SCOPING OPINION:

Proposed Lime Down Solar Park

Case Reference: EN010168

22 August 2024

Title:
Figure 21-2: Location of Cumulative Solar Infrastructure in Proximity to Lime Down Index

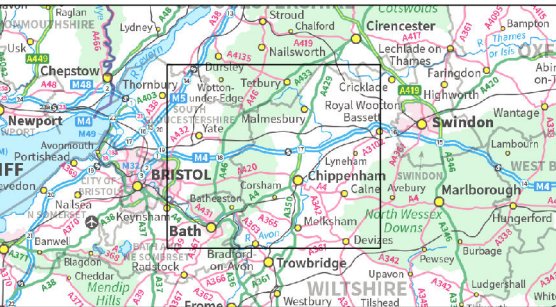
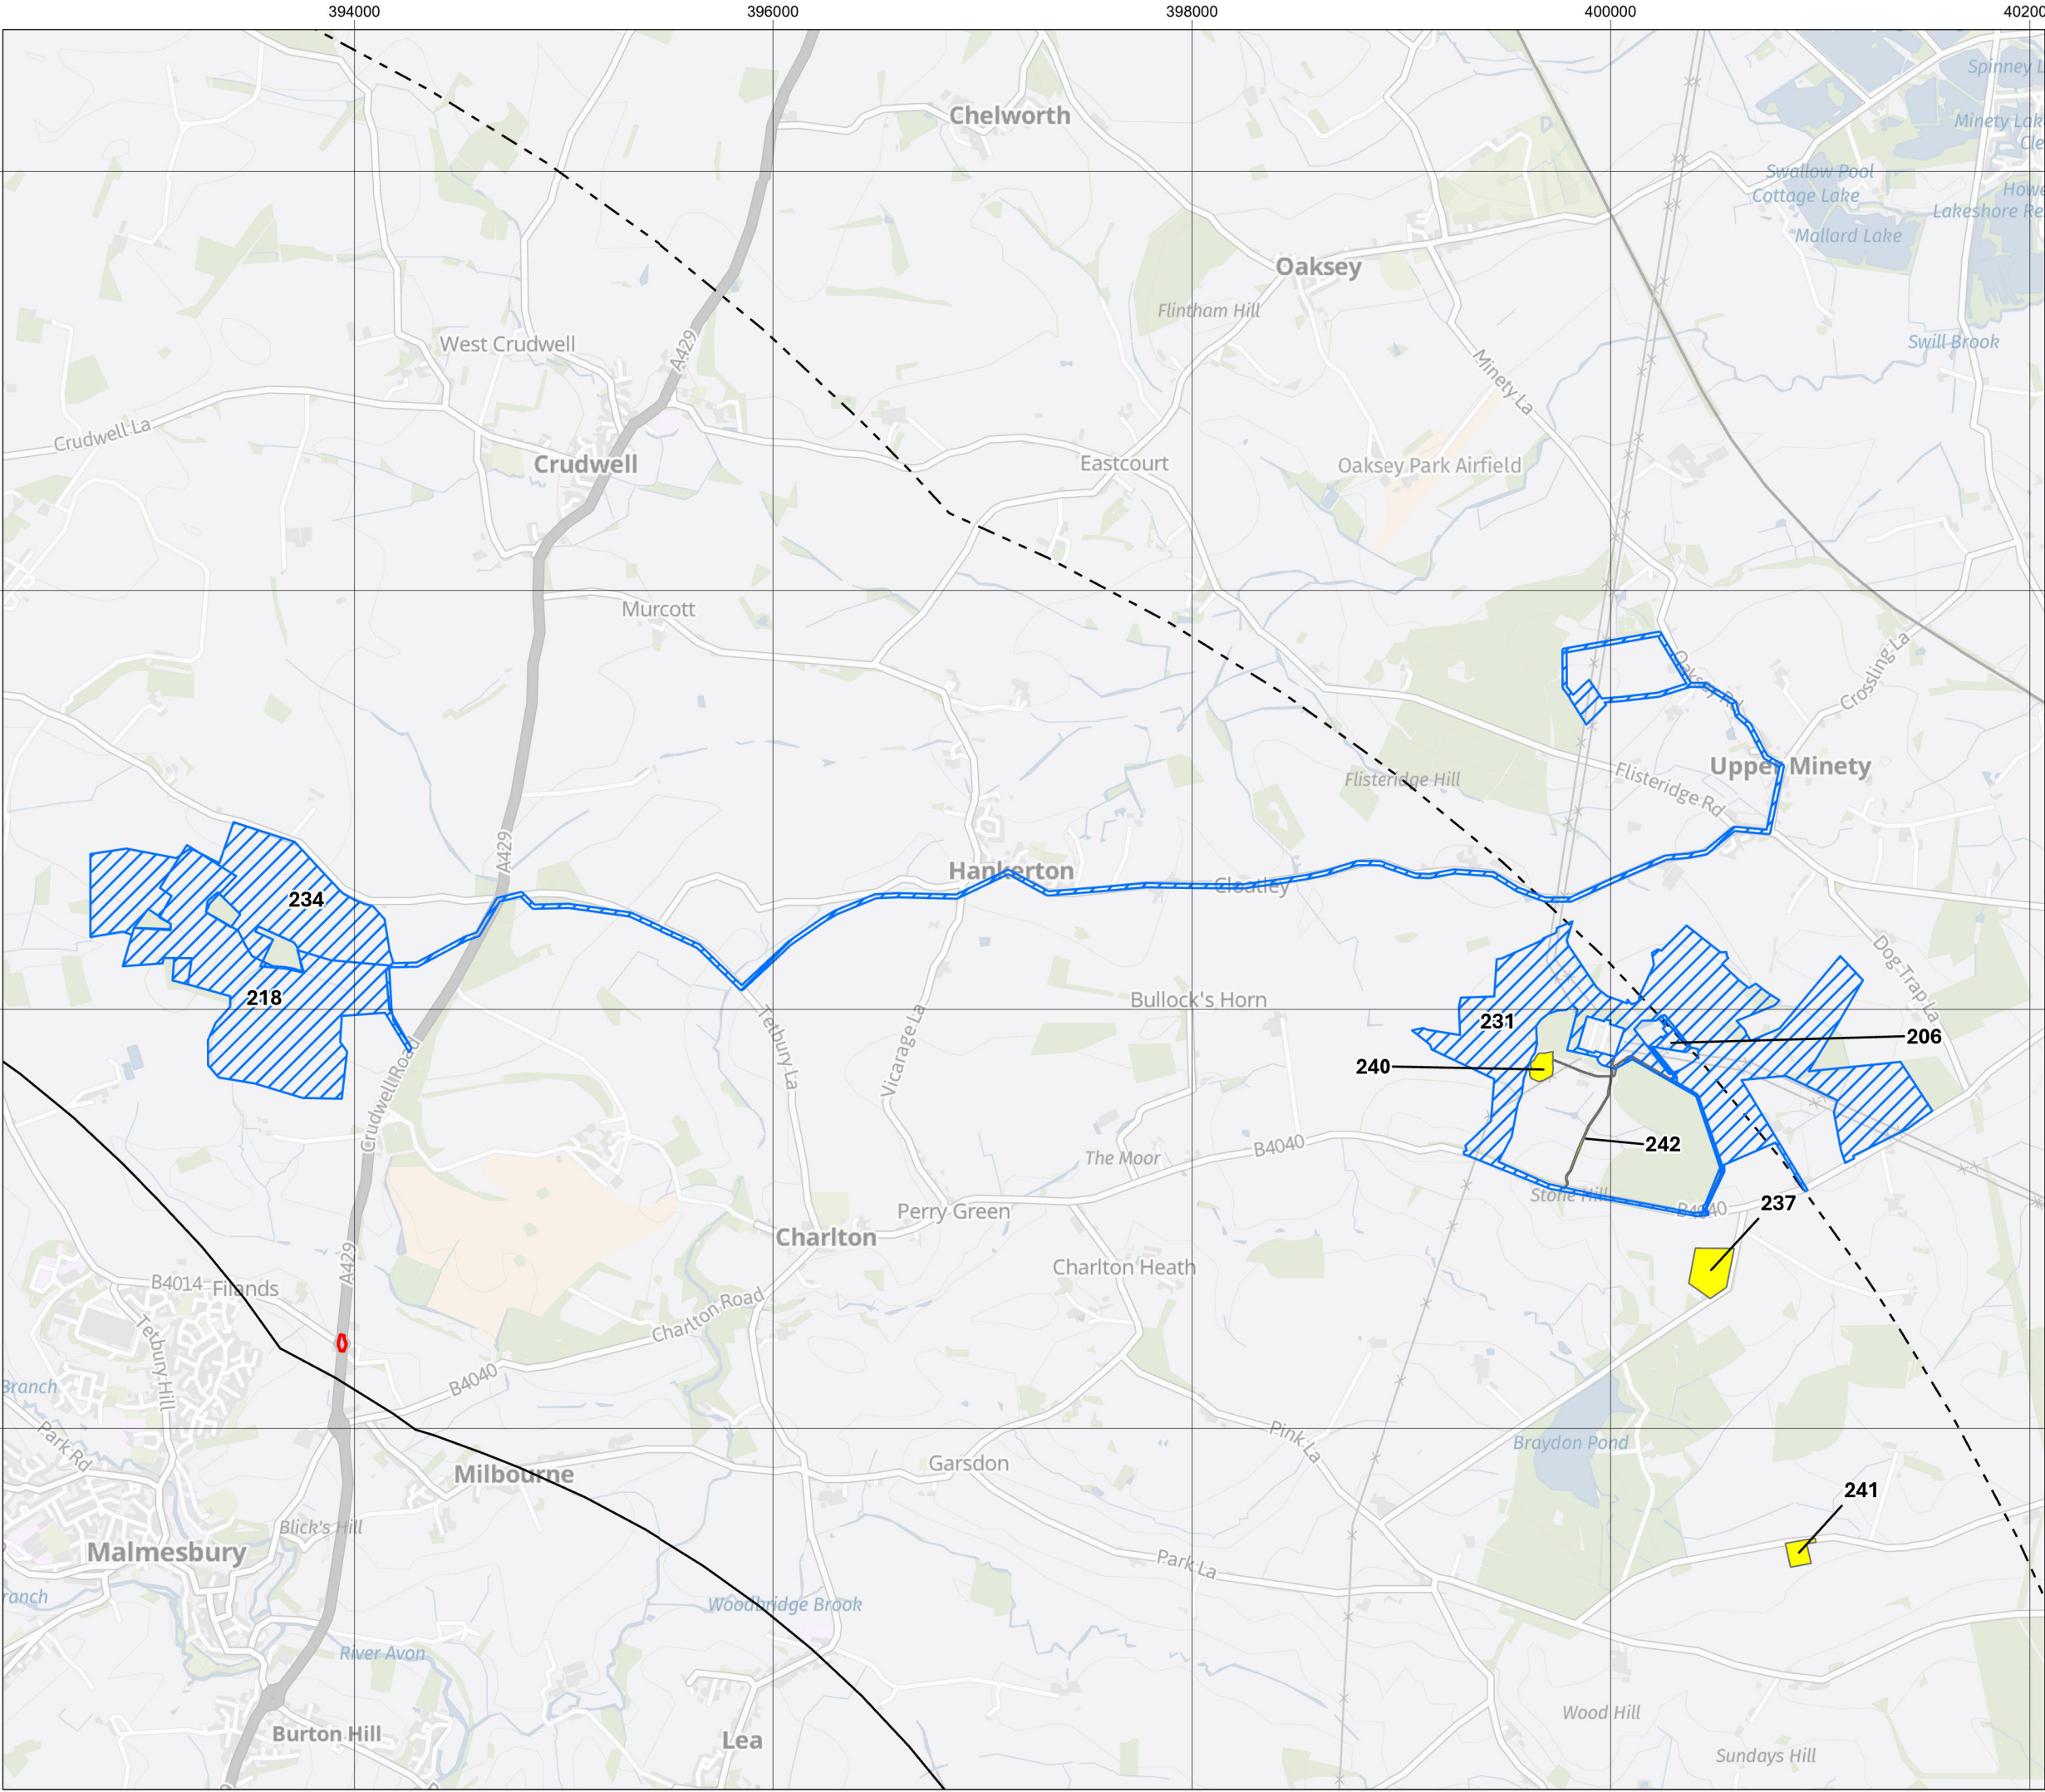
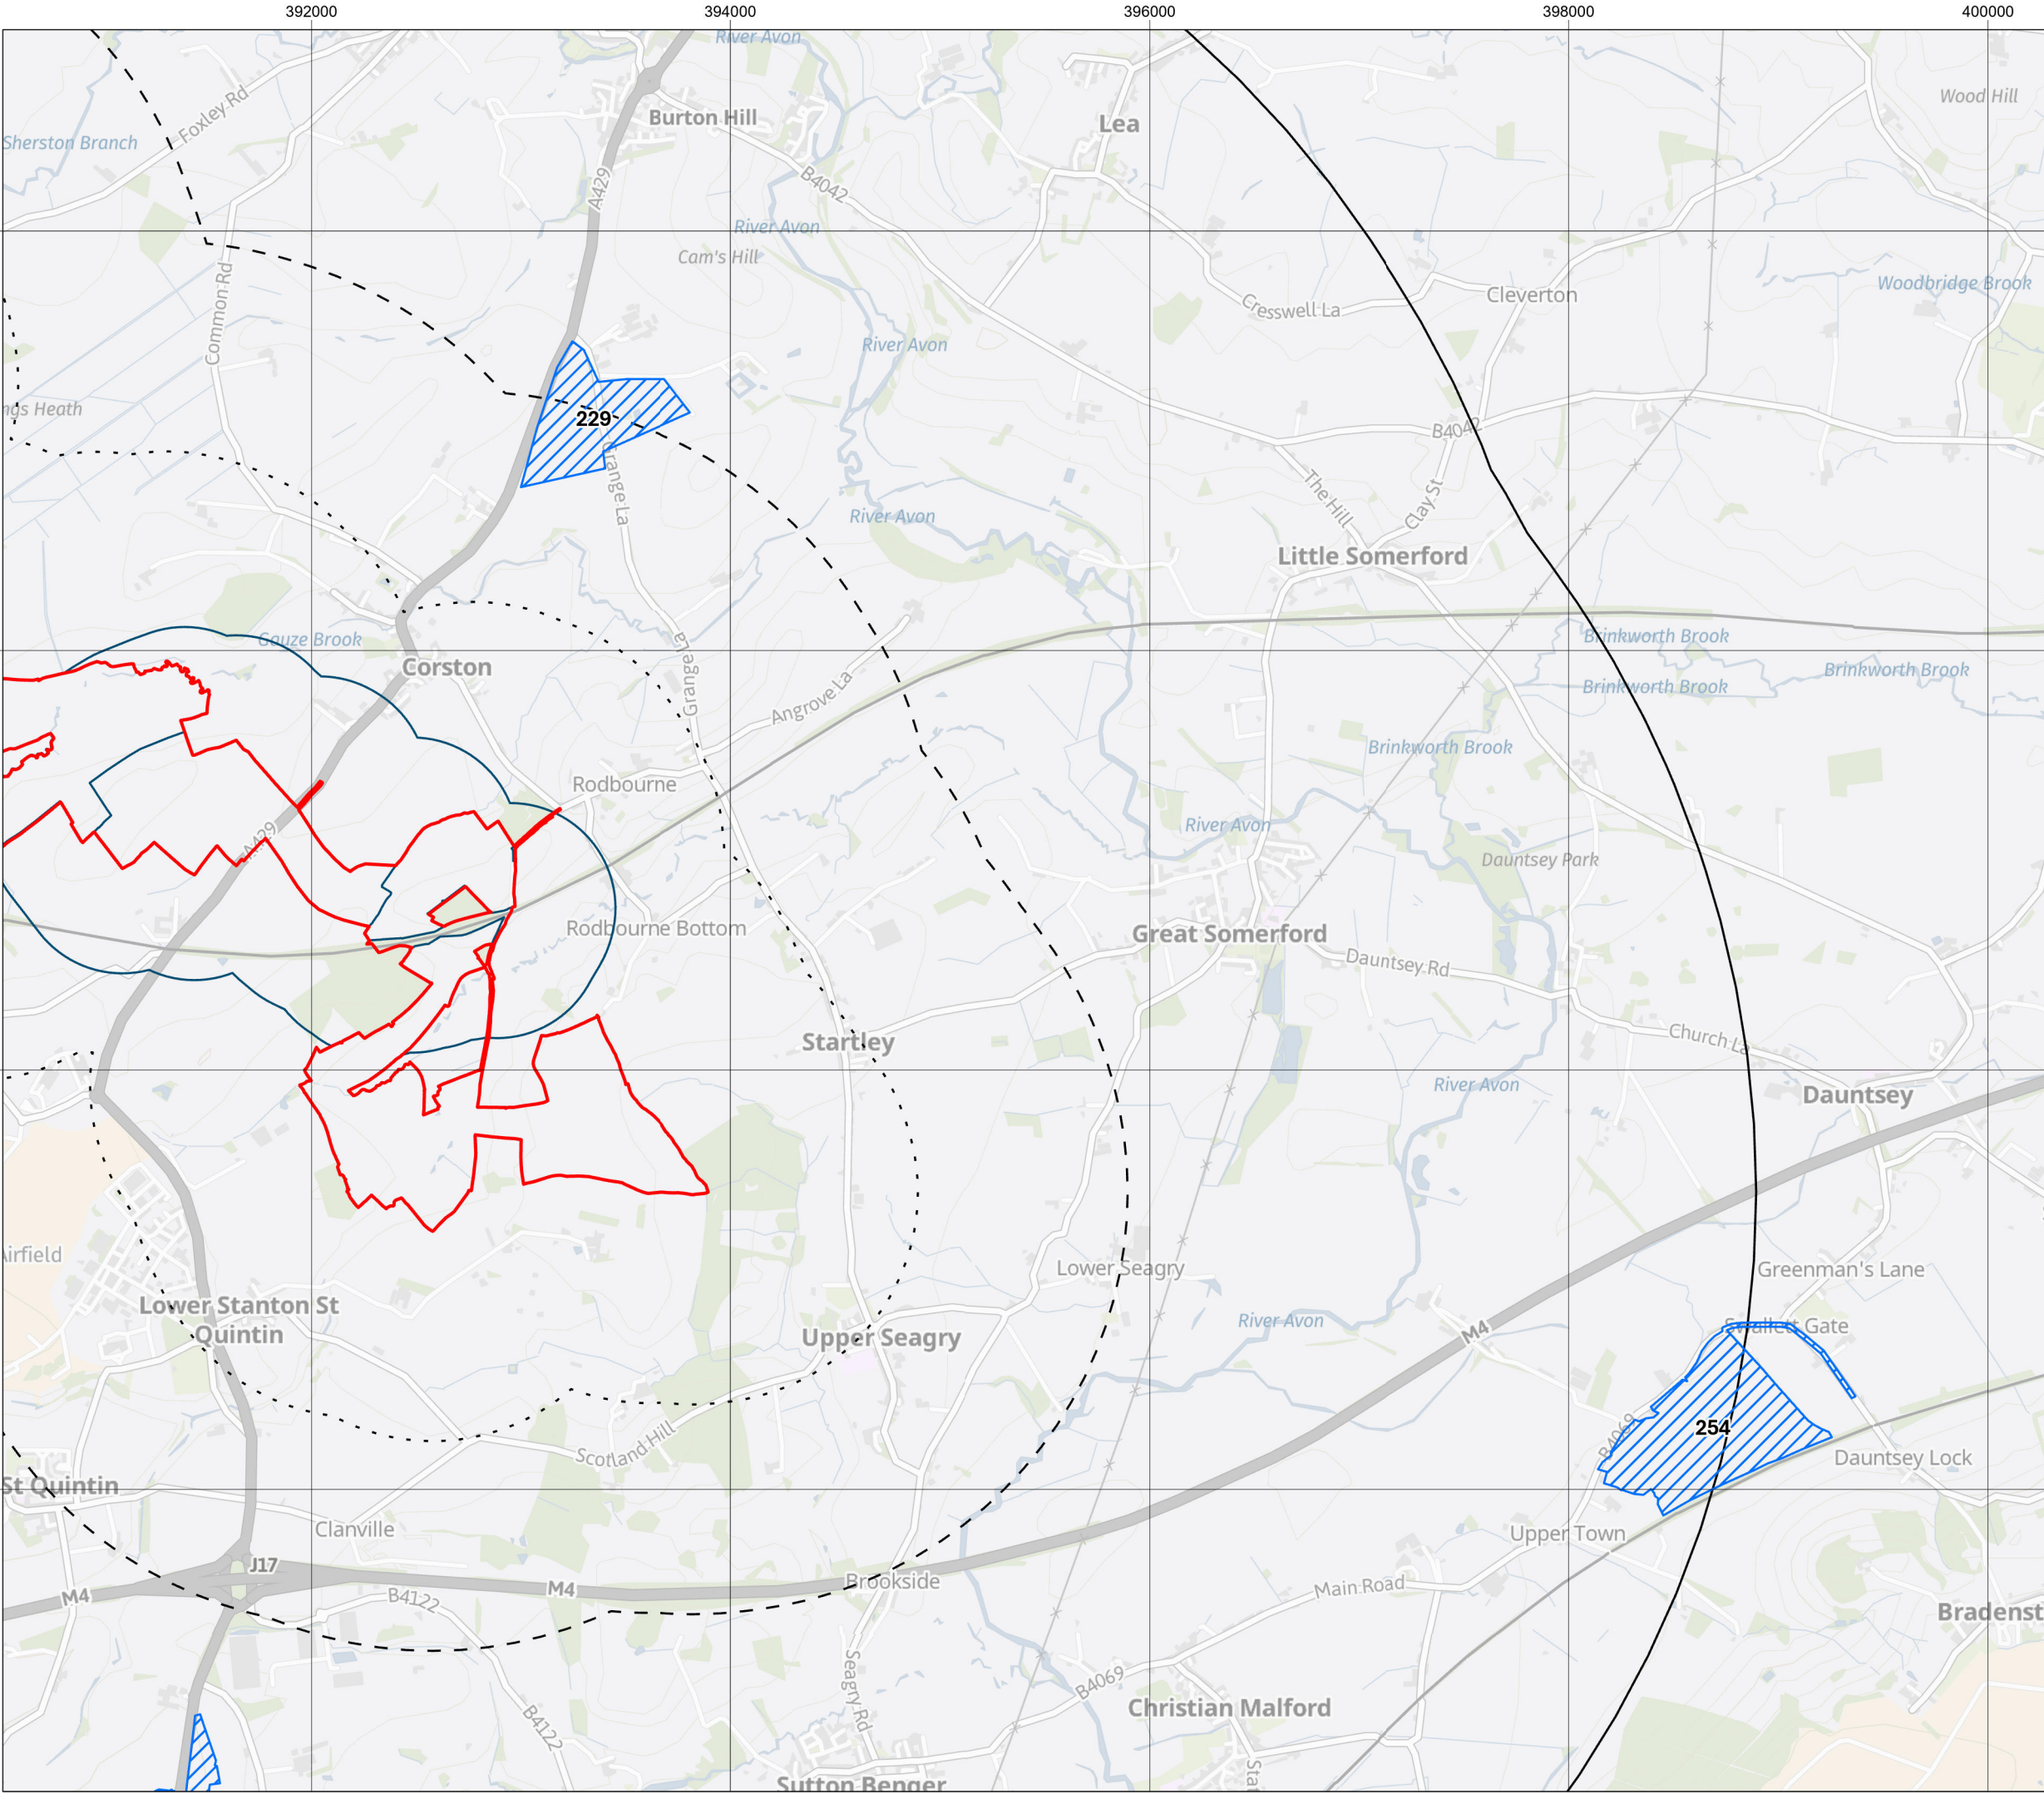
ID	Ref	Description	Inspectorate's comments
221	Para 2.2	Cumulative Effects Assessment (CEA)	The ES should include information on the location of the developments included in the CEA and the distance from the Proposed Development. This should be supported by a figure depicting the locations and extent of cumulative developments in relation to the Proposed Development.
222	Para 2.2.18 and 2.3.7	Reporting of significant effects	The Scoping Report states that the ES " <i>will highlight residual effects which remain following the implementation of suitable mitigation measures</i> ". The Inspectorate considers that the significance of effects prior to the implementation of mitigation measures should also be reported. This is to enable an understanding of the anticipated effectiveness of mitigation measures.
223	Para 2.3.5	Mitigation	The Inspectorate notes that various outline management plans, which will contain proposed mitigation measures, will be submitted with the DCO application. The outline plans should be sufficiently detailed to provide confidence in the delivery of mitigation, particularly that relied upon within the ES to avoid or reduce significant effects.
